Appendix A: Summary of Submissions and Responses to Issues Raised in Submissions

Block 5 Remediation, Part of EPA Remediation Site 21122, Barangaroo Central (SSD 6533)

Second Response to Submissions, October 2015

Remediation and Land Forming Works
Development Application - Block 5 Remediation
Earthworks Drawing

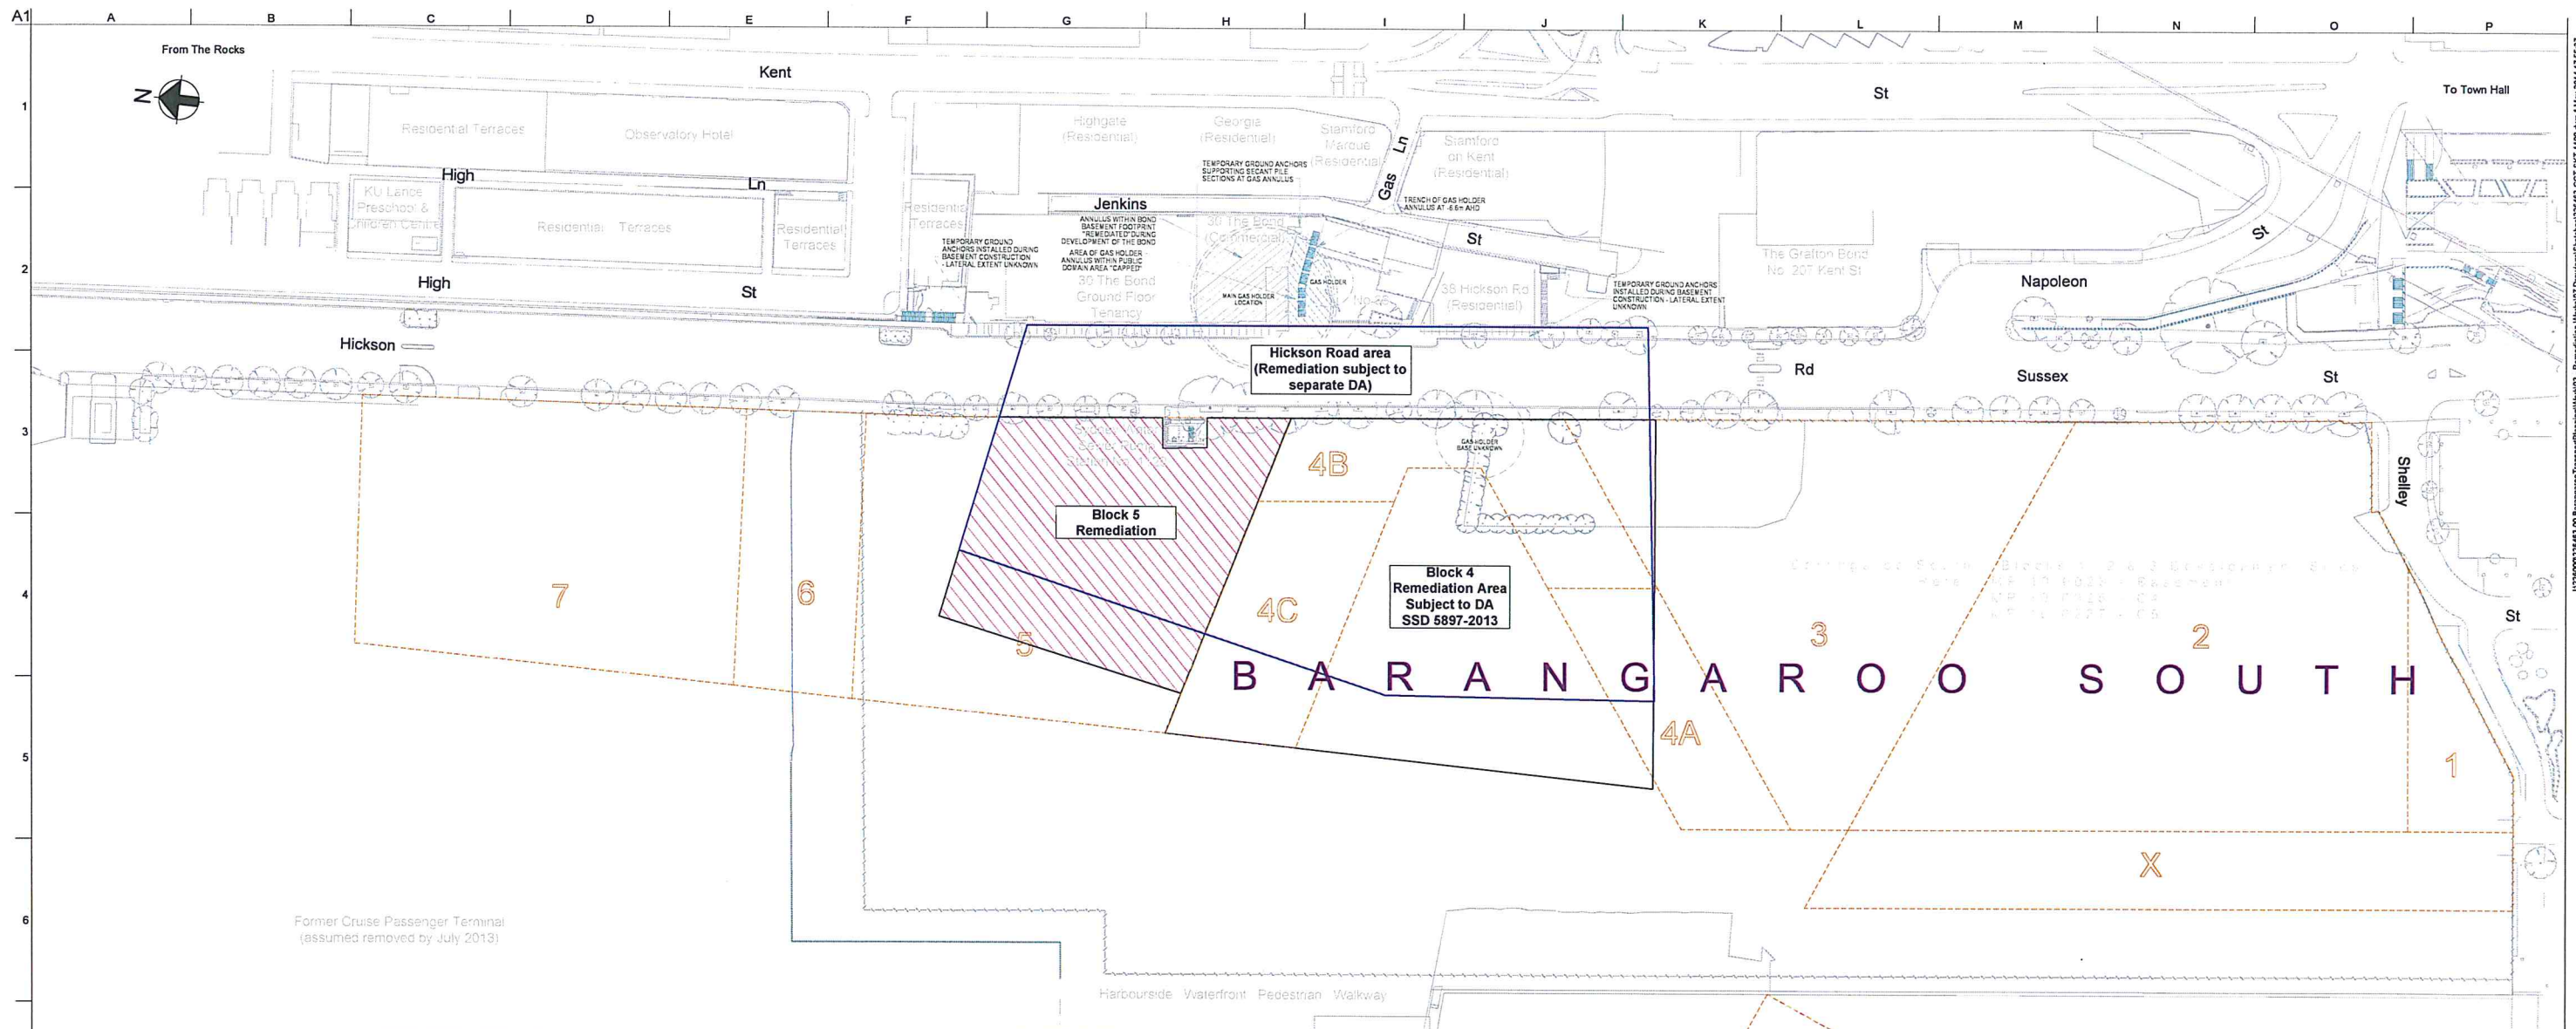
Issue no.	Key Issues Summary	Lend Lease Response
25	Proposed excavation exceeds remediation extent The development contemplated by the Block 5 DA involves excavation of a large area of land which is much larger than the "blue" area which is identified in the applicant's own HHERA/Remediation Extent/RAP documentation as requiring remediation (see pages 45 and 46 of EIS). The RTS explains that additional land is required for "battering" to access the excavations and further excavation. The "blue area" overestimates the area requiring remediation in any event. The proposed excavations are larger than what is actually required to address the contamination.	The majority of the matters in this RtS Issue 25 have been raised previously by Jemena following the first public exhibition period, with a response included by Lend Lease in the previous Block 5 RtS, prepared by JBA and dated July 2015. Refer response to this issue previously detailed in the Block 5 RtS - Appendix A, RtS Ref A58 (JBA Jul 2015). The remediation extent (i.e. the "blue area") reflects the indicative remediation area determined by the RAP and subsequent Auditor approval, and has been agreed with the EPA. The extent of potential excavation sought in SSD 6533 – as shown on the Block 5 Remediation Earthworks Drawing BB2_PA1_A007 (yellow shading) – is proposed to allow for potential additional excavation/batters if required to "chase out" the full extent of VMP Remediation Works. It does not relate to development works.
